## *Rezoning Petition Review*

**Date of Review:** March 14, 2008 (**Revised October 8, 2008**)

**Rezoning Petition #:** 08-75

**Location of Property:** Approximately 4.22 acres located on the north side of E. Woodlawn Road between Park Rd and Halstead Drive

PROJECT NO. FFD-06020
 FILENAME: FFD06020-R21
 DESIGNED BY: CSS
 DRAWN BY: CSS
 SCALE: 1" = 40'
 DATE: 10-14-2008
 SHEET NO. **TD-1**

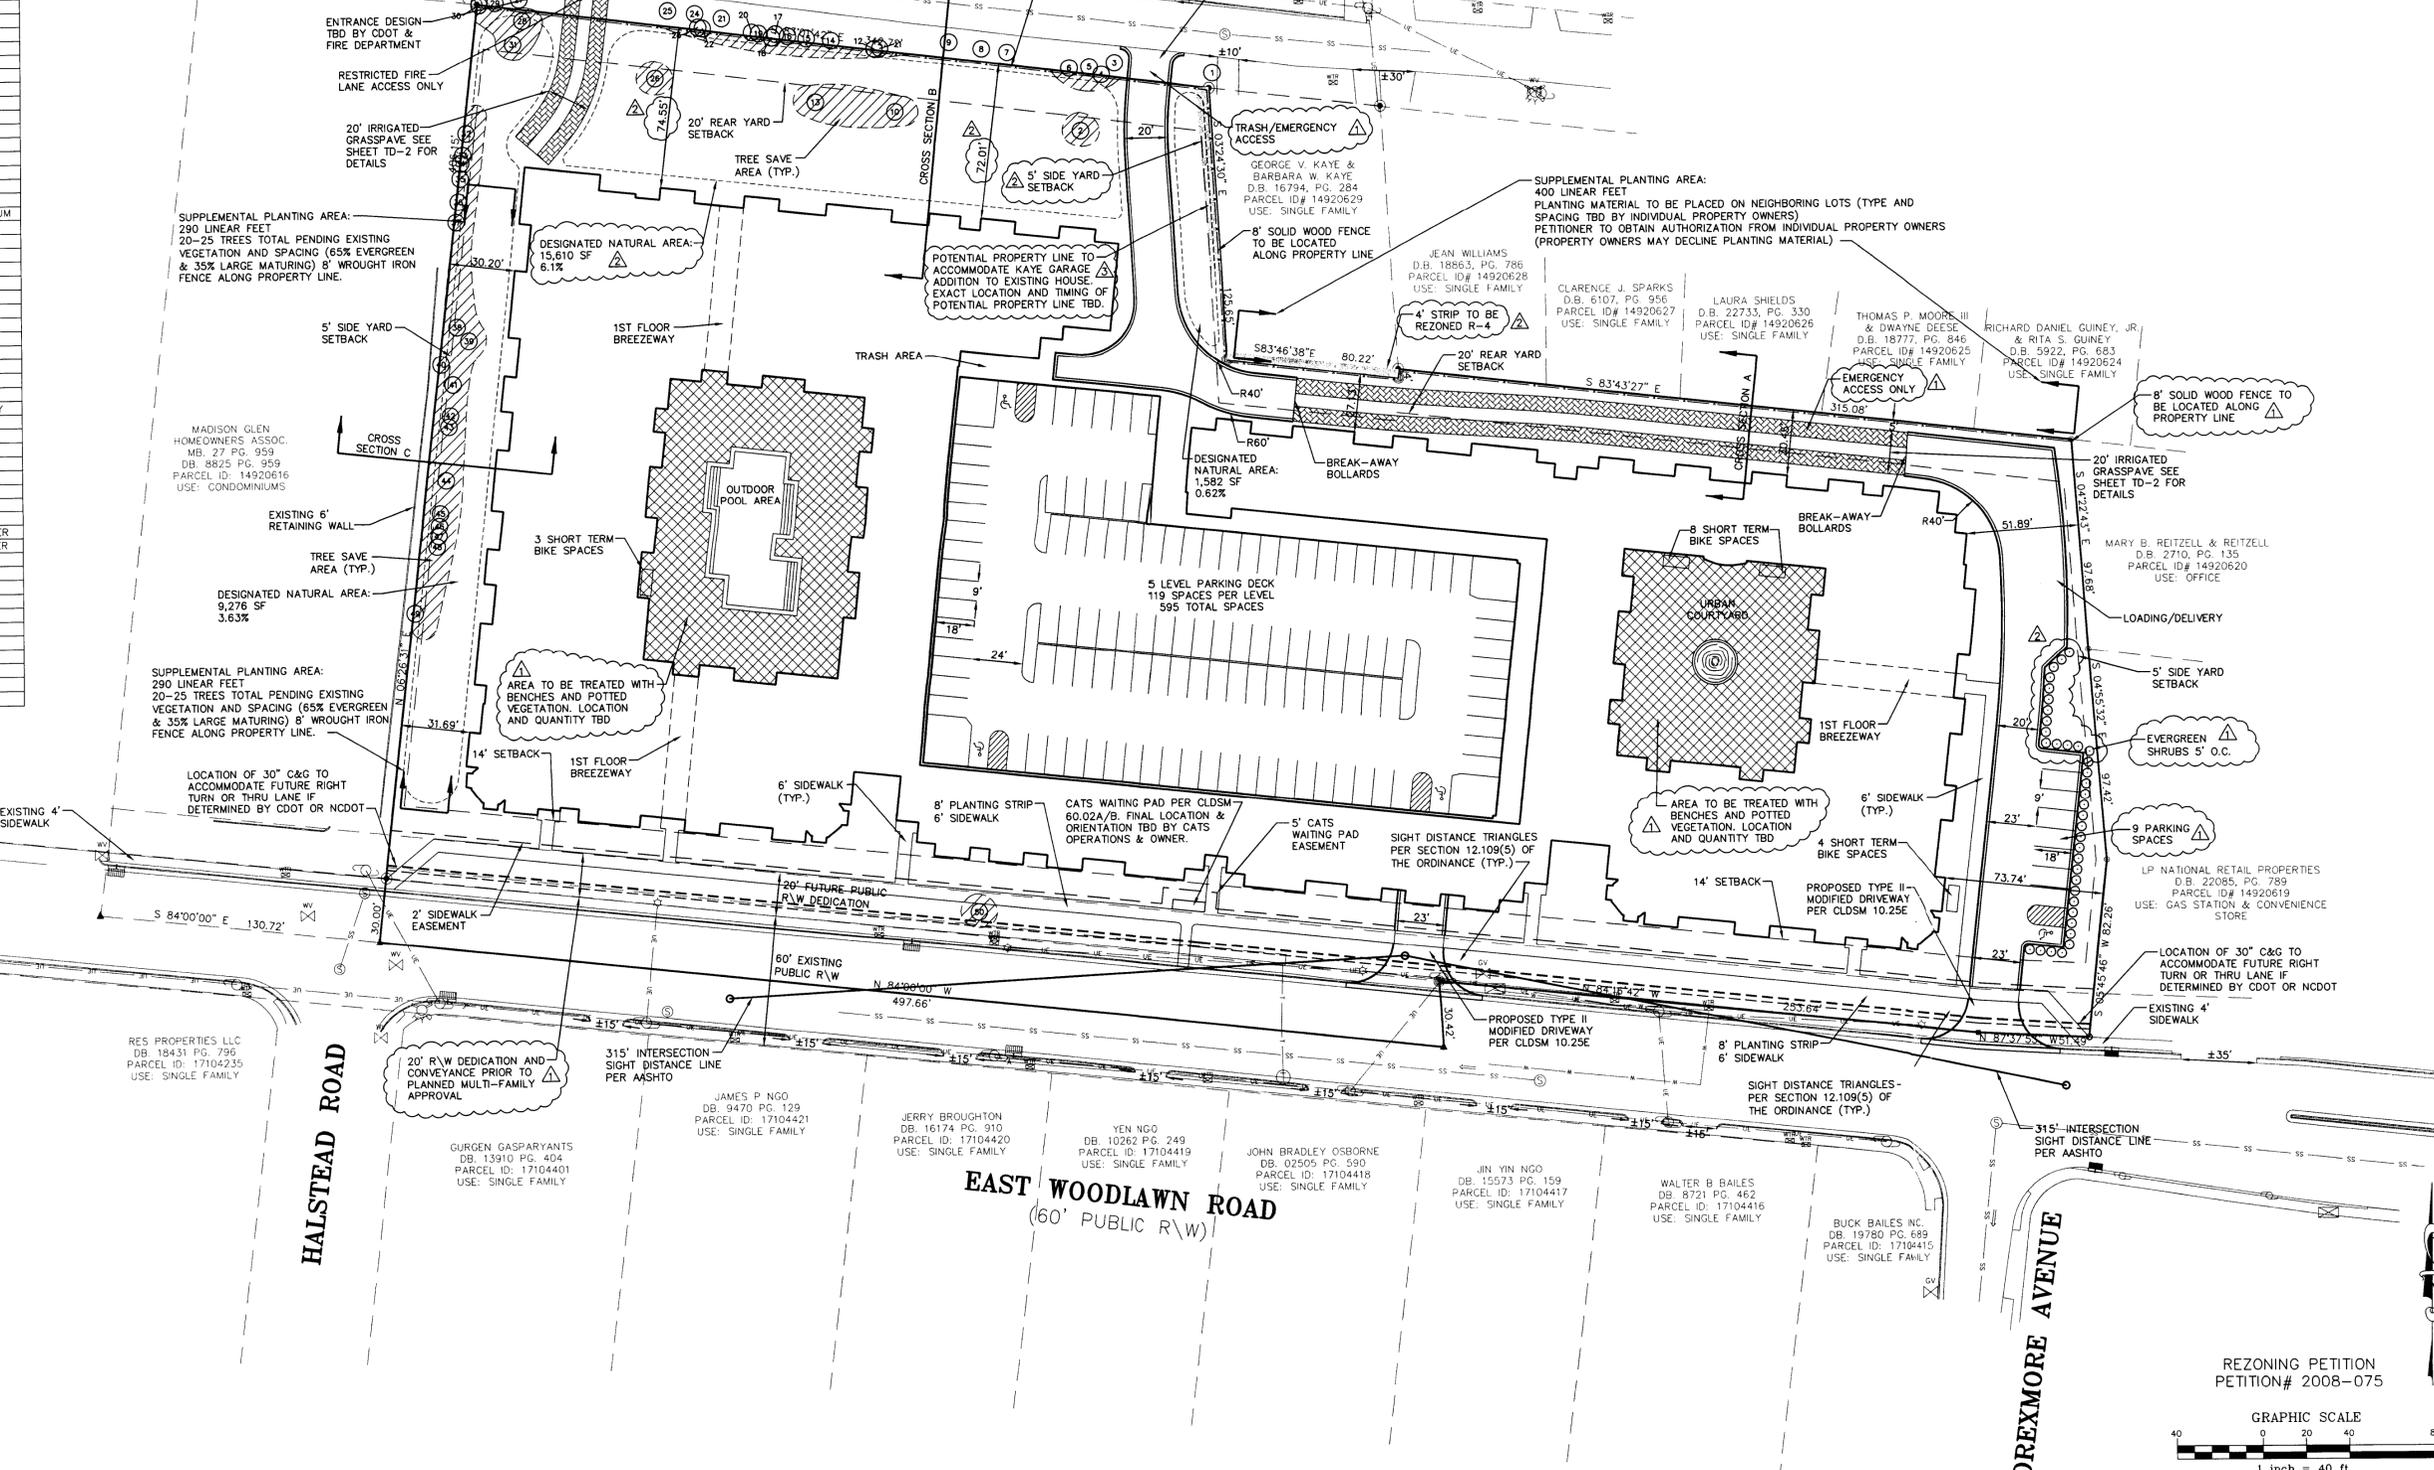
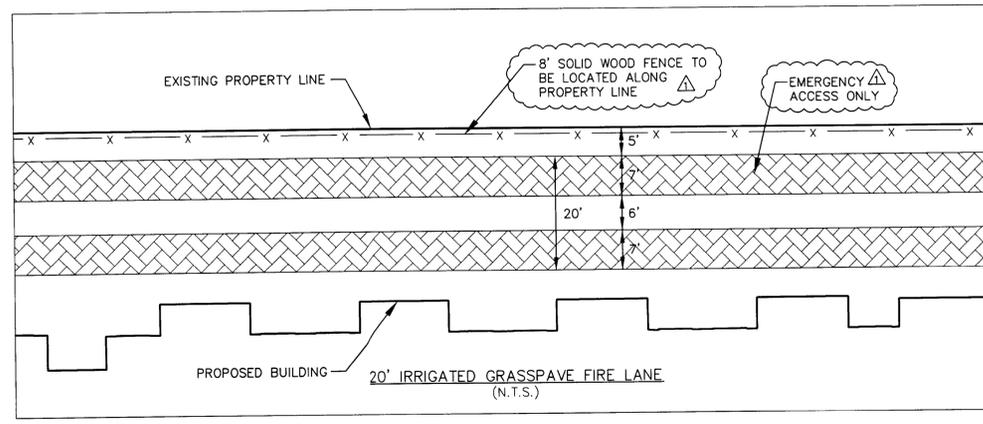
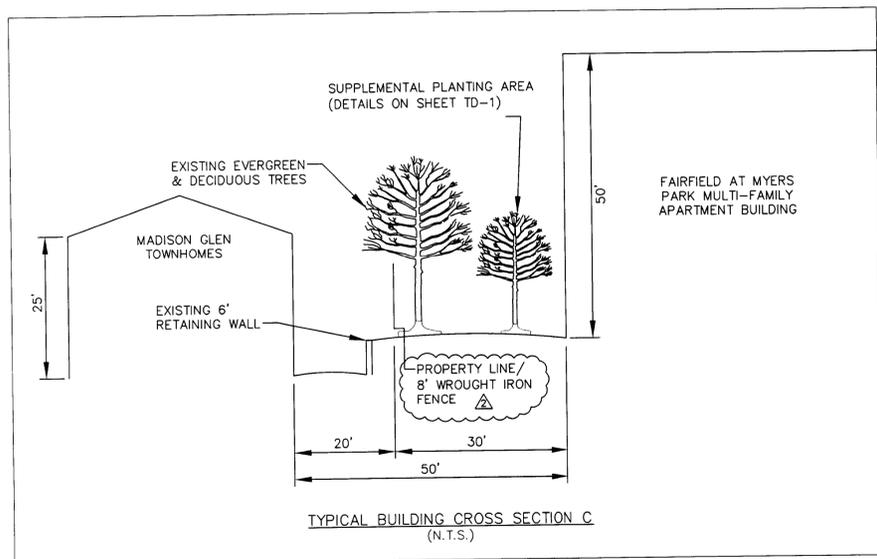
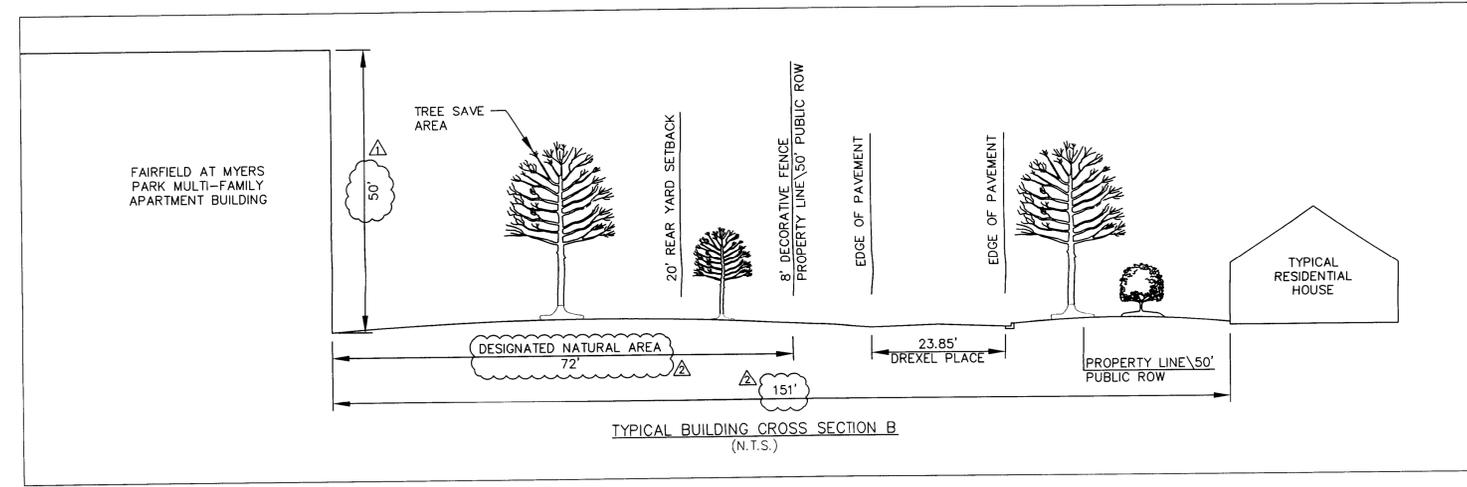
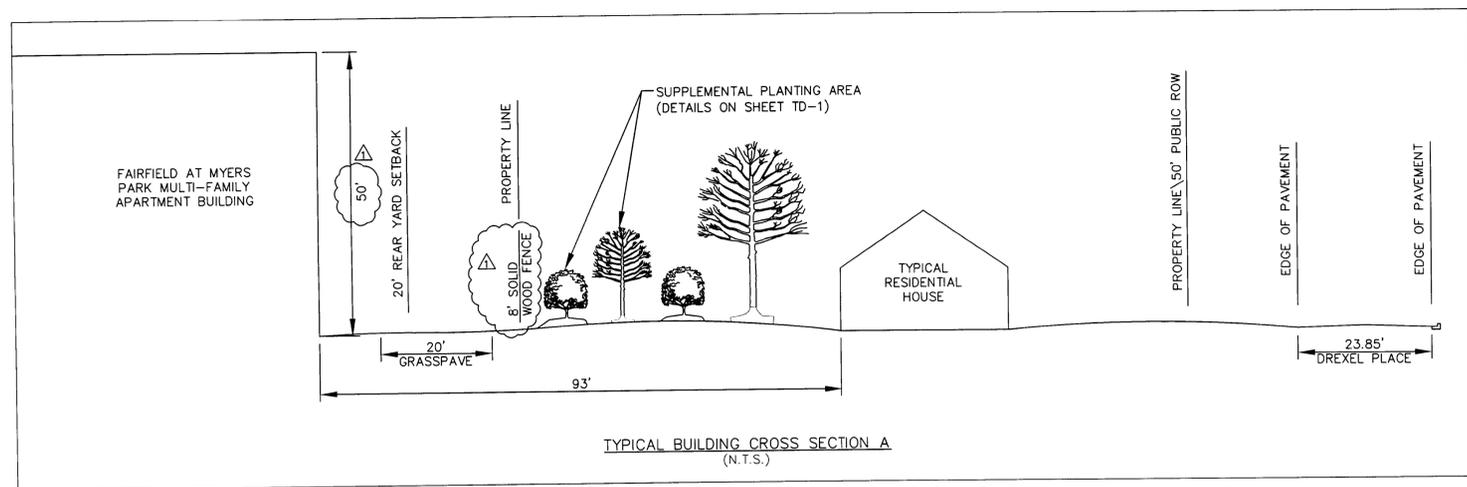
**Recommendations Concerning Storm Water:** **Remove Storm Water Management Note 1) and instead Include the following notes on the petition.**

The petitioner shall comply with the Charlotte City Council approved and adopted Post Construction Controls Ordinance.

The following agencies must be contacted prior to construction regarding wetland and water quality permits:

Section 401 Permit NCDEHNR – Raleigh Office (919) 733-1786  
Section 404 Permit US Army Corps of Engineers (704) 271-4854
